Rezoning Transportation Analysis

Petition Number: 2025-092

General Location Identifier: 04324101, 04306213

Date	Description
09-24-25	First Review (KC)

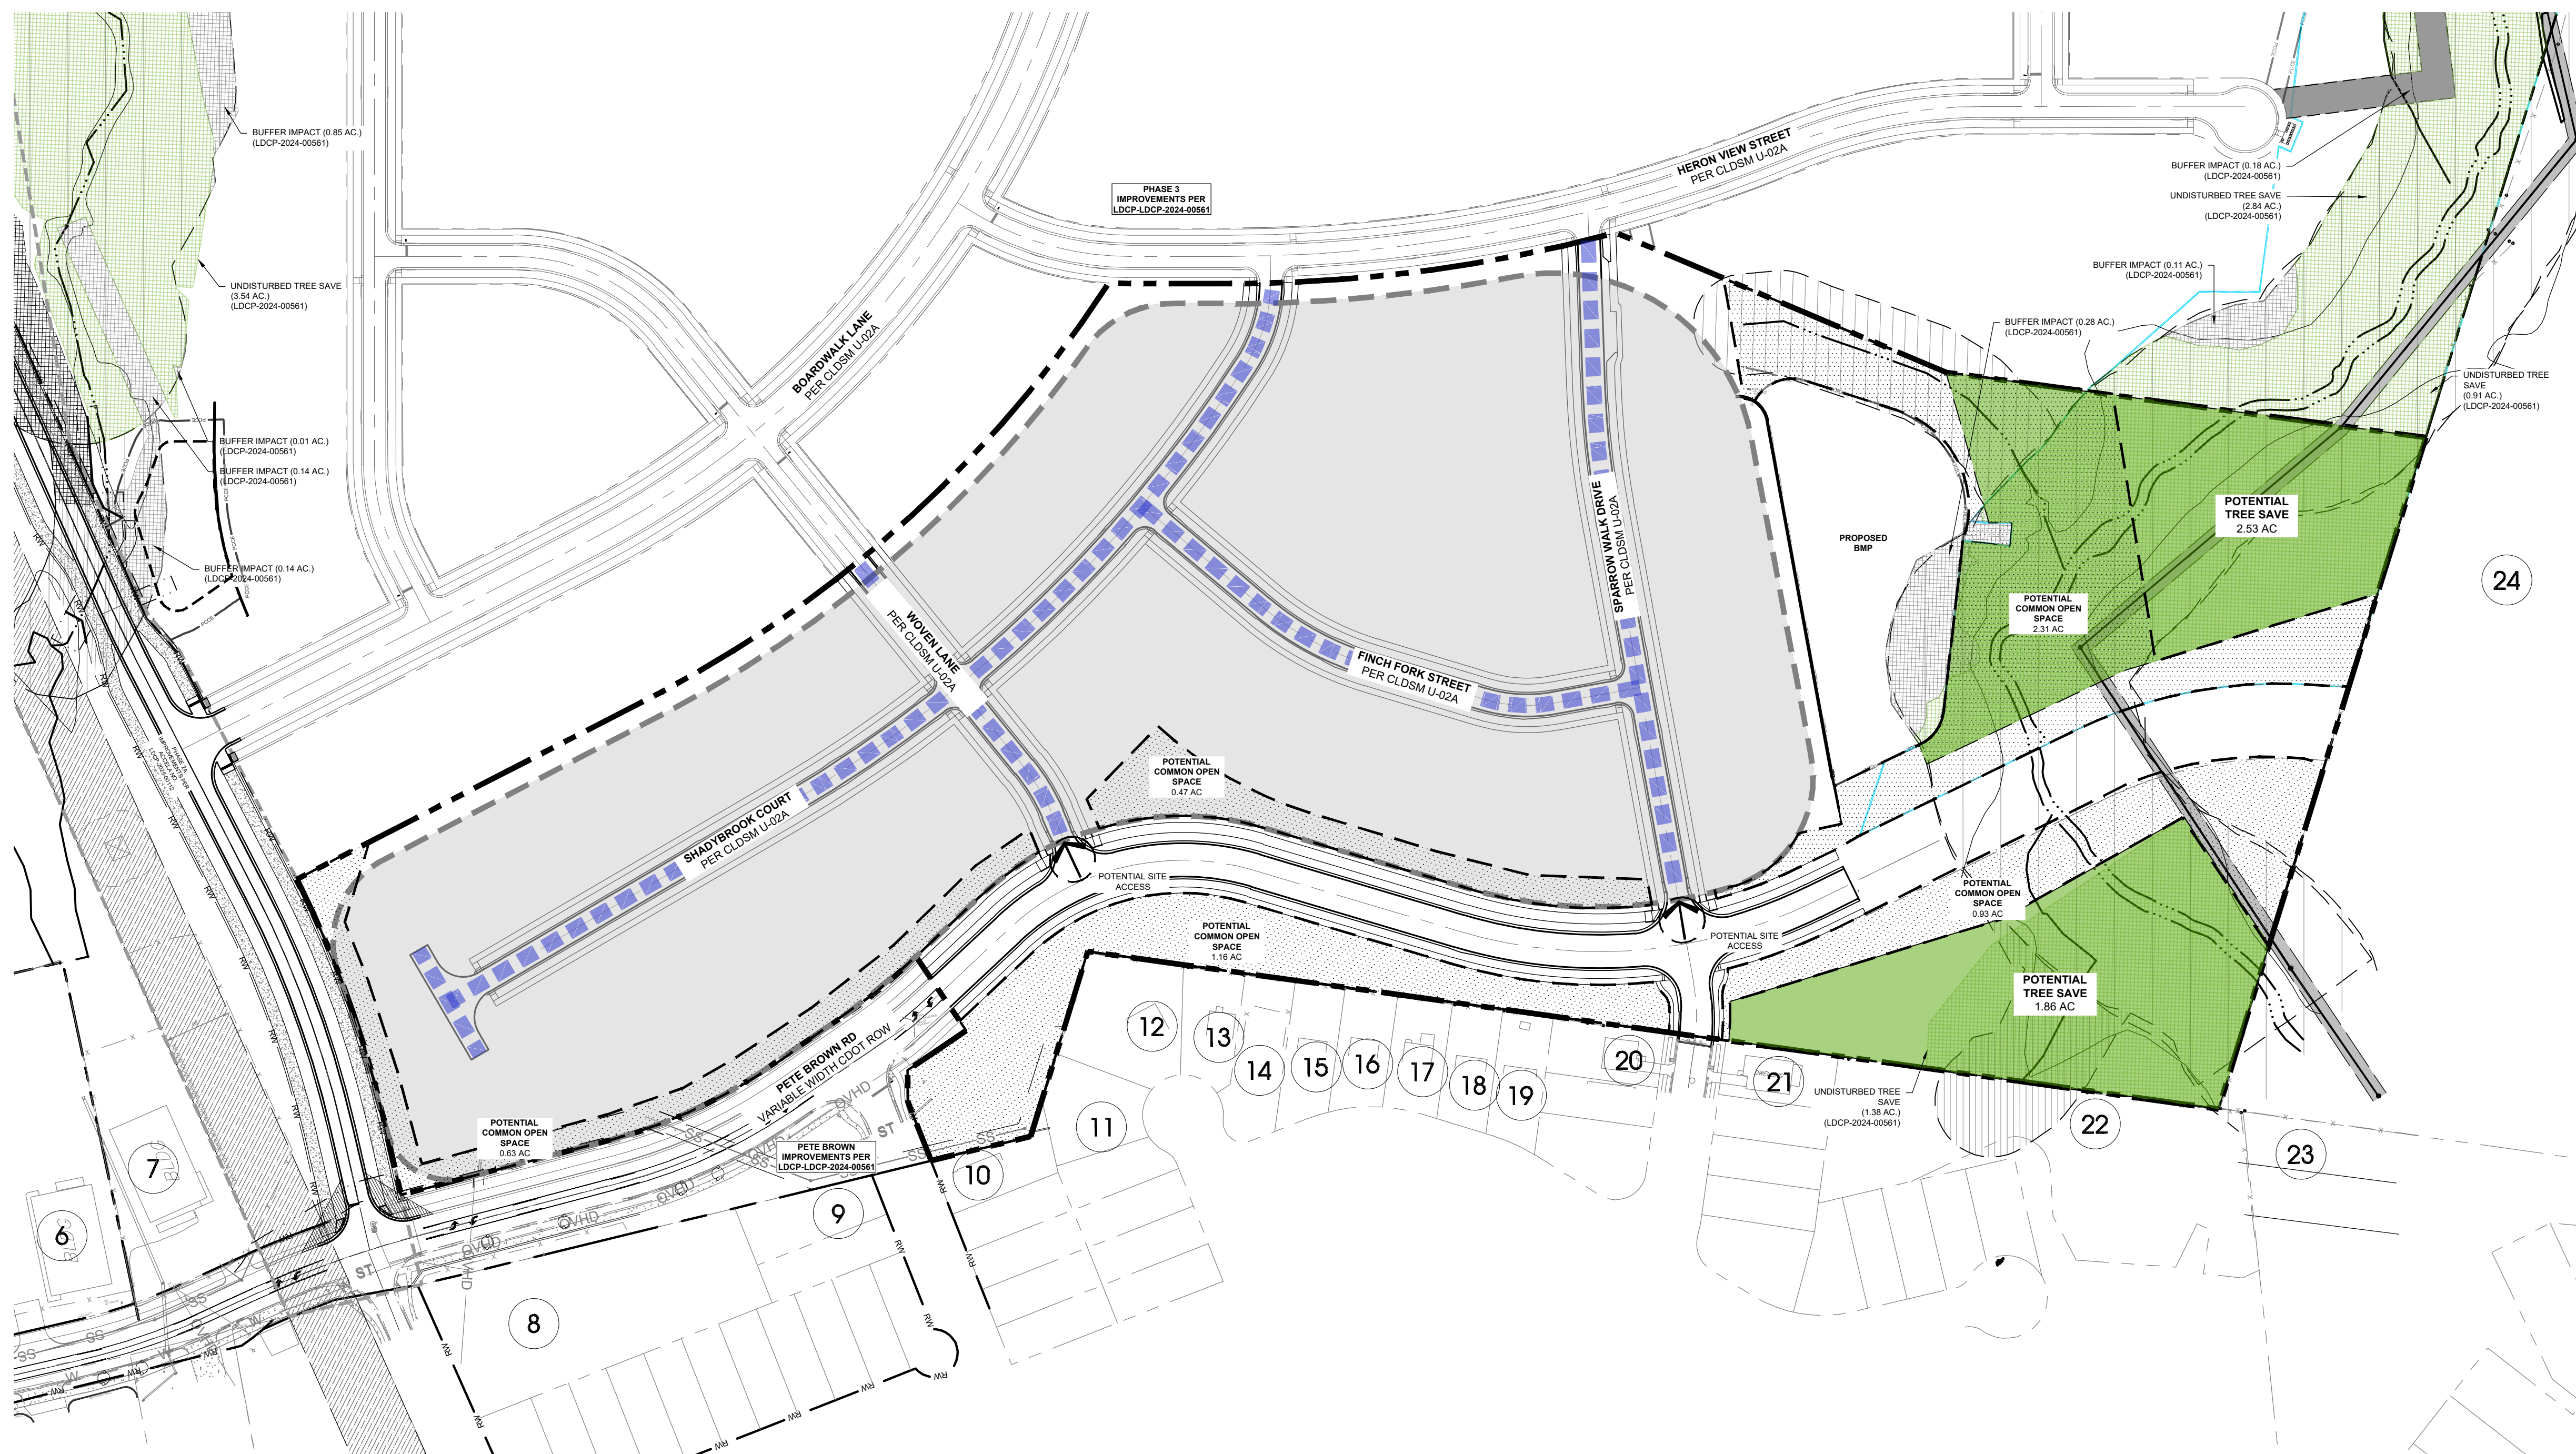
1. Curbline:

- a. **Pete Brown Road:** Location of future curb and gutter is to be located 27' from centerline.

Label and dimension the curb and gutter from the centerline for each road on the site plan.

- Revise site plan and conditional note(s) to commit to dedicate 33.5" right-of-way from the road centerline. The site plan shall label and dimension the right-of-way from the road centerline for Shadybrook Court, Woven Lane, Finch Fork Street and Sparrow Walk Drive.

- Revise site plan and conditional note(s) to commit to constructing Shadybrook Court, Woven Lane, Finch Fork Street and Sparrow Walk Drive as "Local Residential Wide Street" U-03A1.
